From: Thomas Callaway
Sent: 31 March 2015 13:23
To: Planning.Responses
Subject: RE: Planning Consultation on: M/15/15/HH

Engineers comments in respect to surface water drainage:

APPLICATION NO: **M/15/15/HH**

Description of Works: Remove existing garage and erect a single storey side extension annexe for a dependant relative.

Proposed Roof Plan

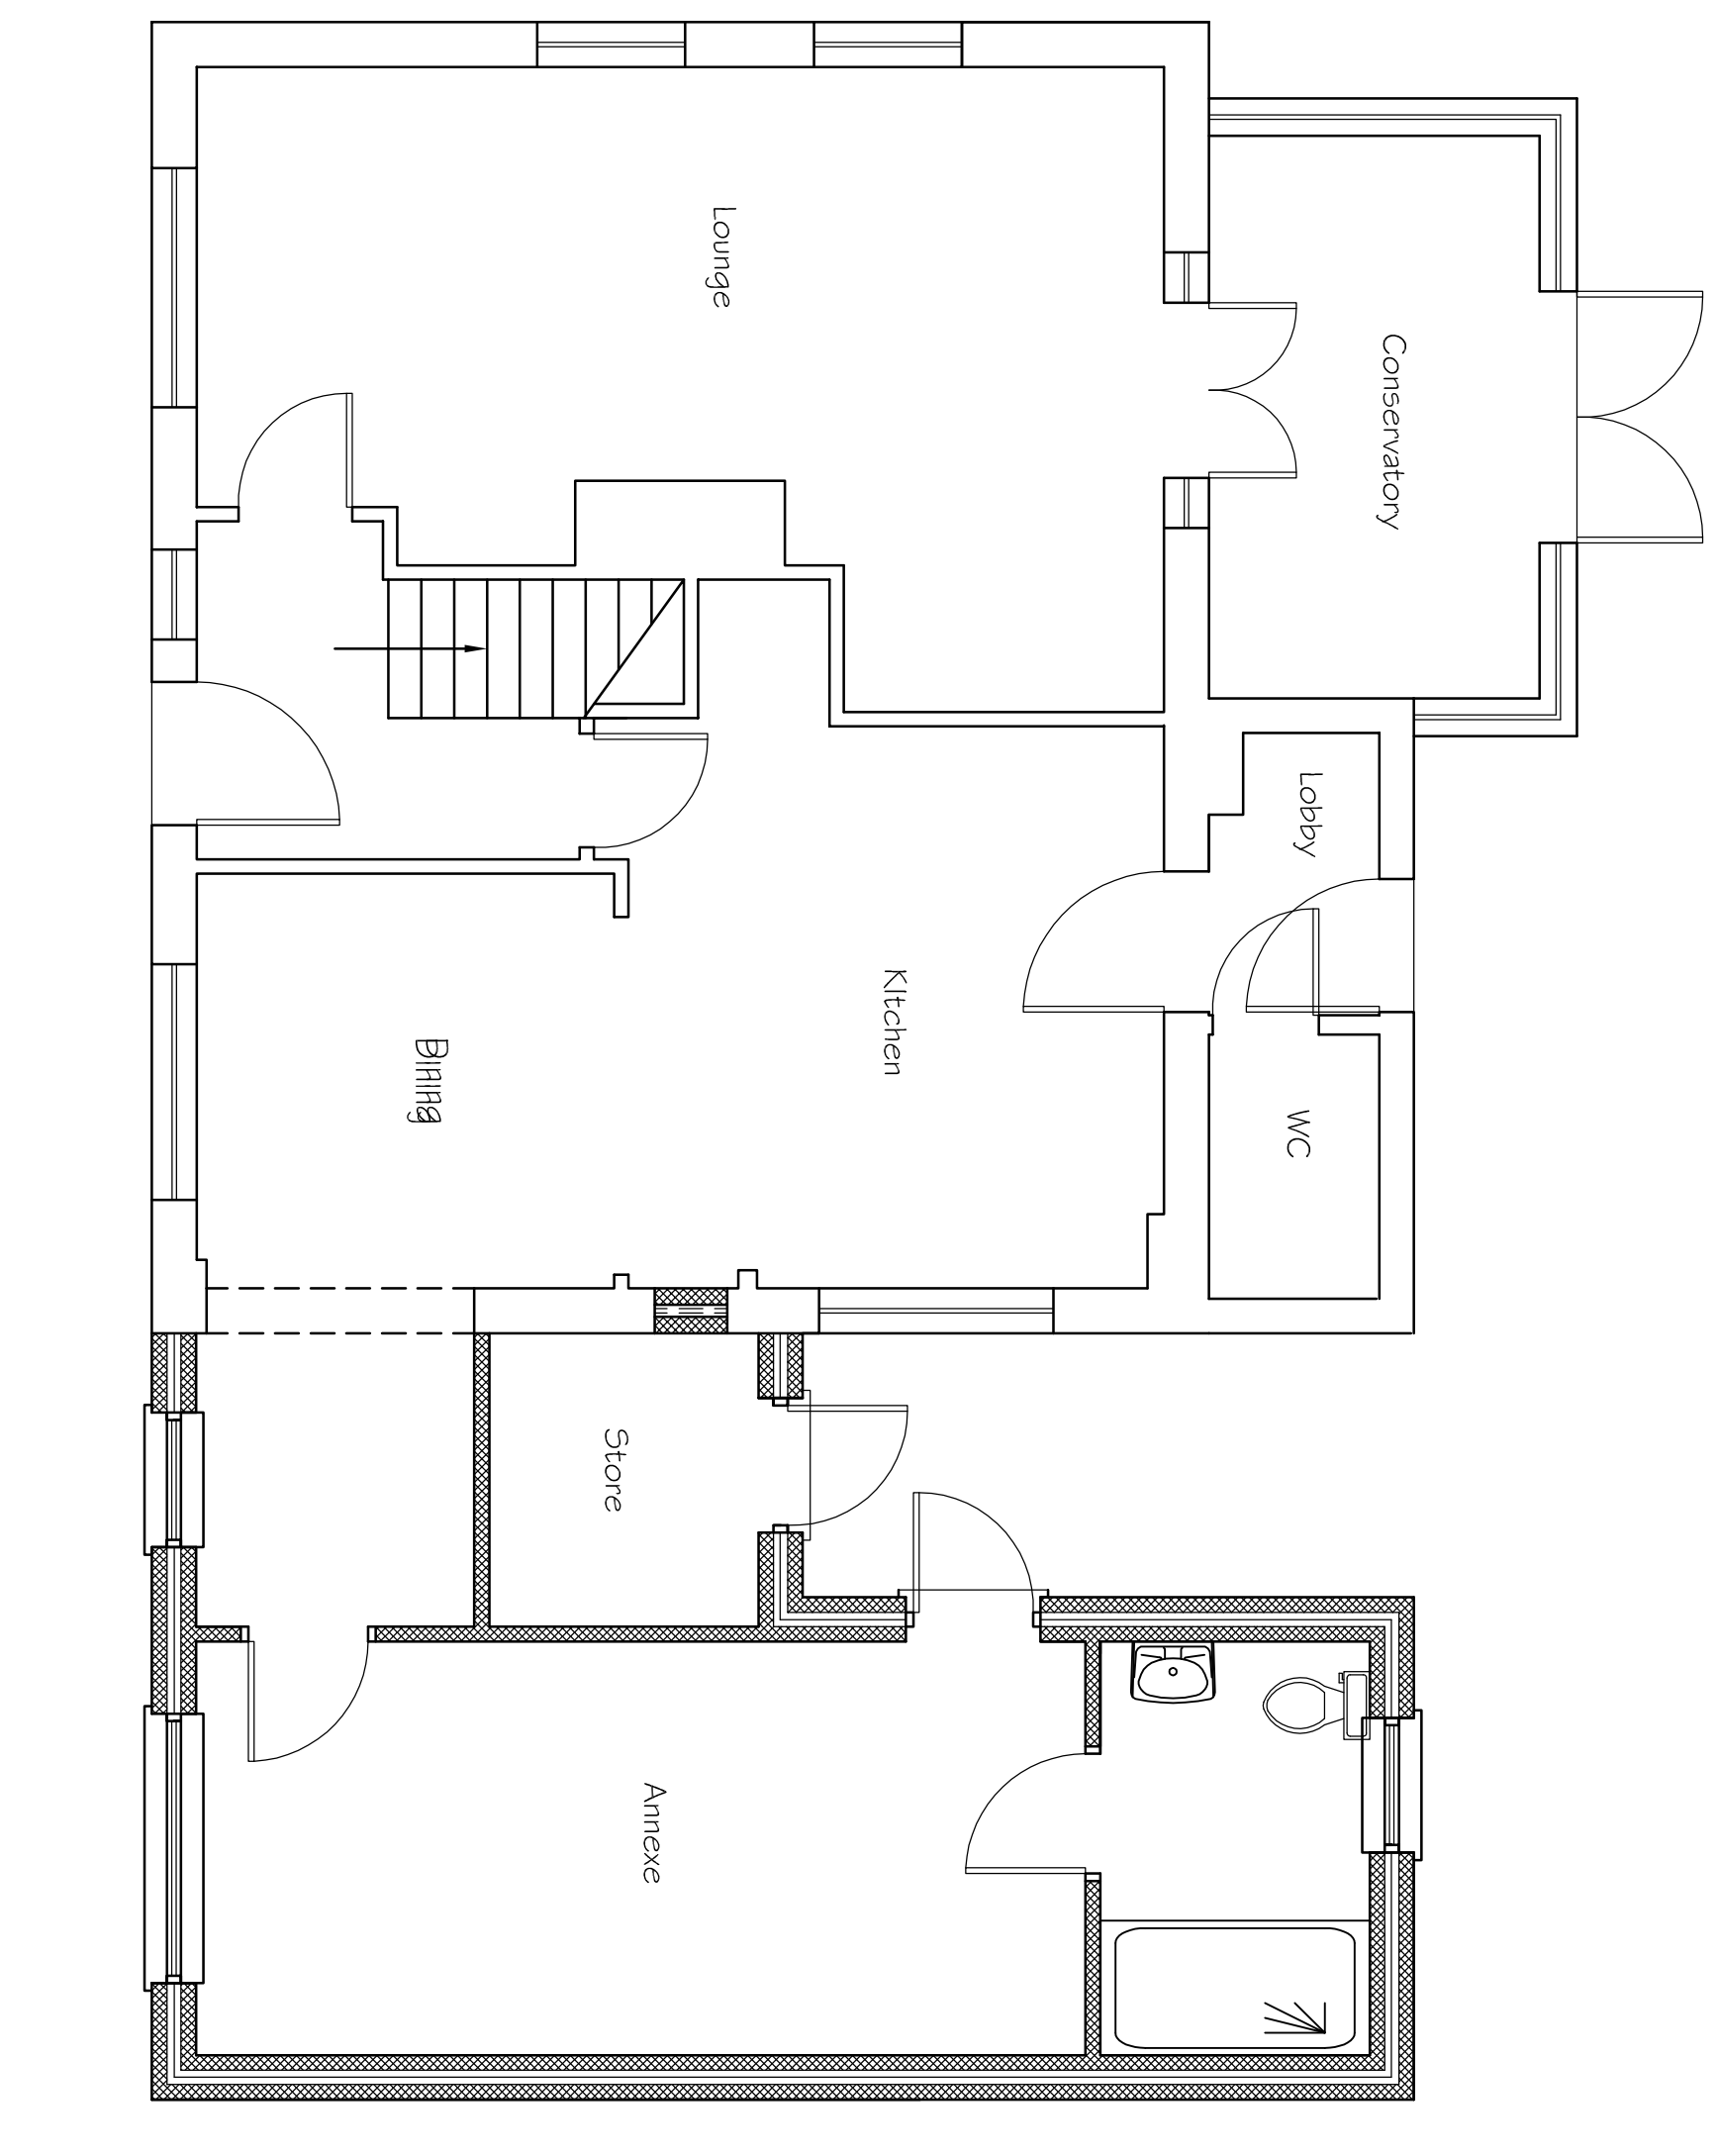
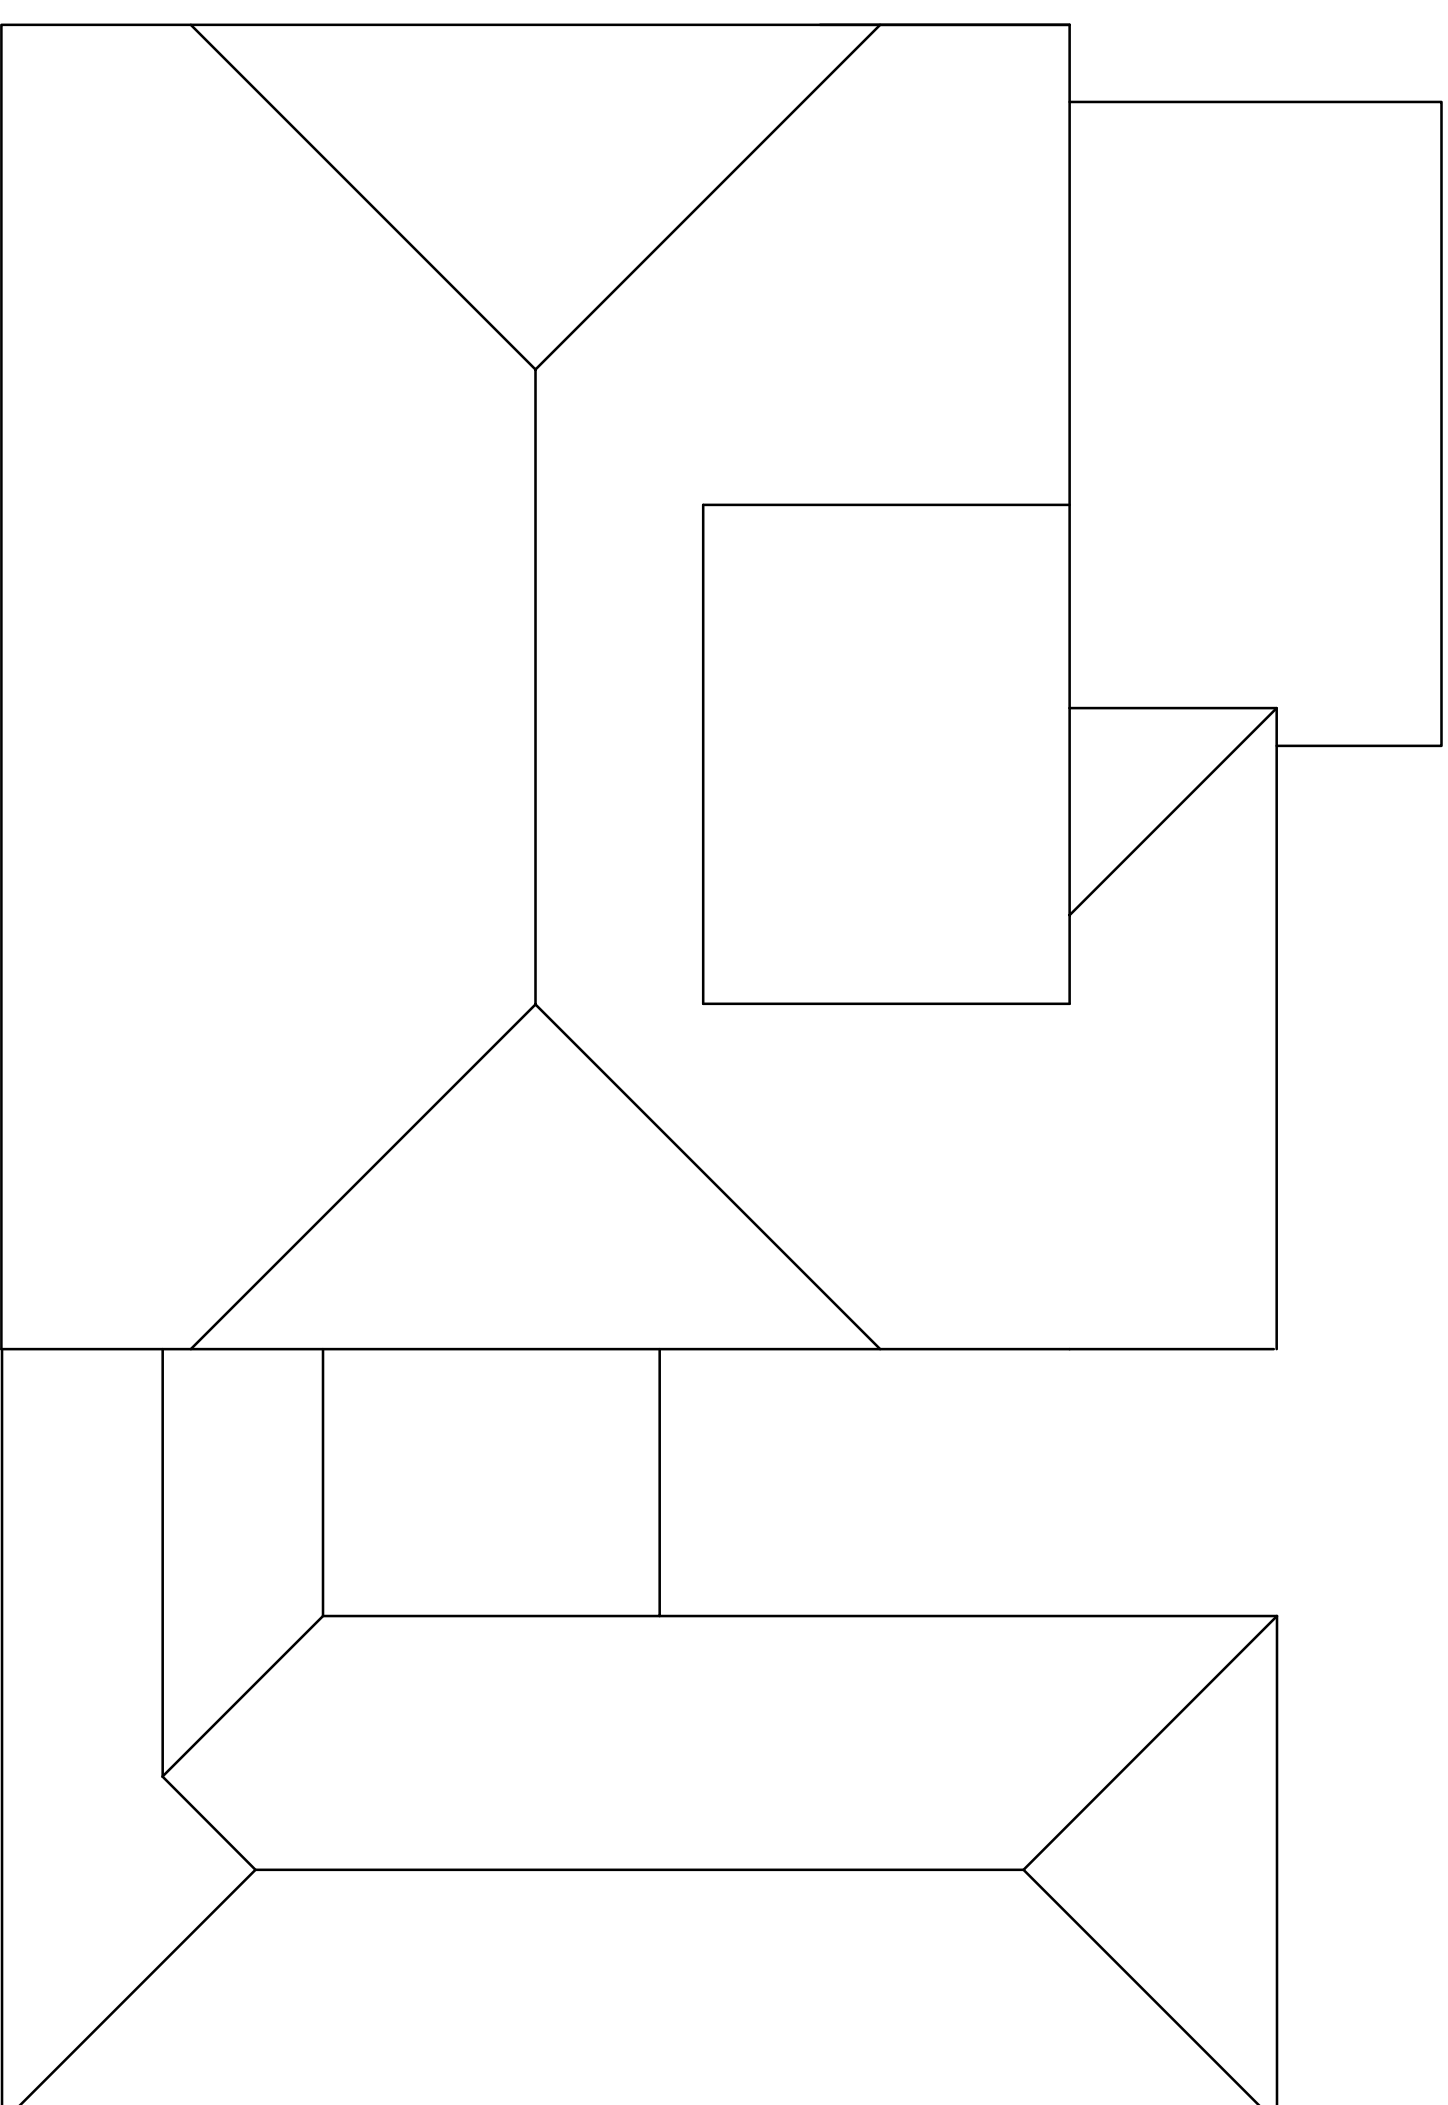
Surface water should be discharged to soakaways or similar for all new roof area.

Infiltration rates for soakage structures are to be based on percolation tests undertaken in the winter period and at the location and depth of the proposed structures. The percolation tests must be carried out in accordance with BRE 365, CIRIA R156 or a similar approved method and cater for the 1 in 10 year storm between the invert of the entry pipe to the soakaway, and the base of the structure. It must also have provision to ensure that there is capacity in the system to contain below ground level the 1 in 100 year event plus 30% on stored volumes, as an allowance for climate change. Adequate freeboard must be provided between the base of the soakaway structure and the highest recorded annual groundwater level identified in that location.

Any SuDS or soakaway design must include adequate groundwater monitoring data to determine the highest winter groundwater table in support of the design. The applicant is advised to discuss the extent of groundwater monitoring with the Council's Engineers. Supplementary guidance notes are also enclosed for information.

Please apply standard conditions ENGD2A.
